**ADC PARKS & GREENSPACE ARBORICULTURE**

**PLANNING APPLICATION:** P/58/15/OUT

**ADDRESS:** Land at Summer Lane Pagham PO21 4NG

**BRIEF DESCRIPTION:** Outline application with some matters reserved for the erection of 90 No. dwellings with associated access & open space. This is a Departure from the Development Plan.

Proposed site layout plan indicating tree locations
and indicative Root Protection Areas.

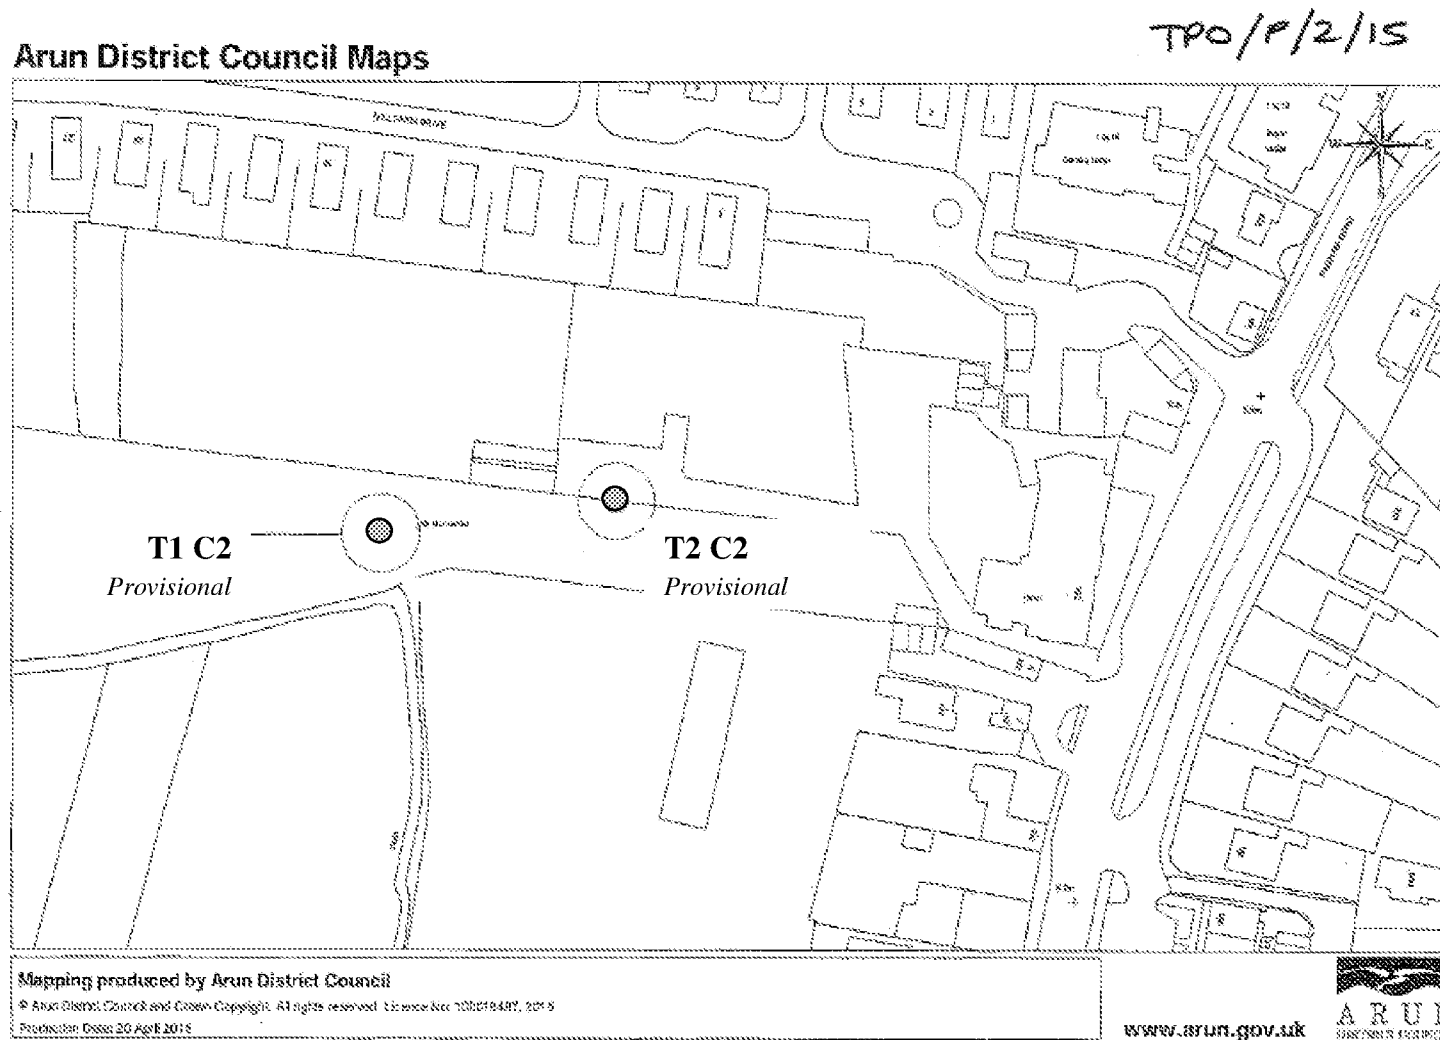
- The applicant has identified the correctly sized RPA's for **T1-T4** (section 3.4, table 2).
- I would agree with the applicants observation that **T1 – T3** location (on the opposite side of a deep drainage ditches) would directly affect the root morphology, and is likely to have caused the root protection area to span offsite (due to the void preventing spanning towards the site).
- I would also agree with the outlined protective measures for **T4**, which would include full implementation of static fencing for the RPA area that spans into the development area.

- **I would have no objection to the proposed protective measures outlined in the application submitted**, as they meet the BS 5837:20102
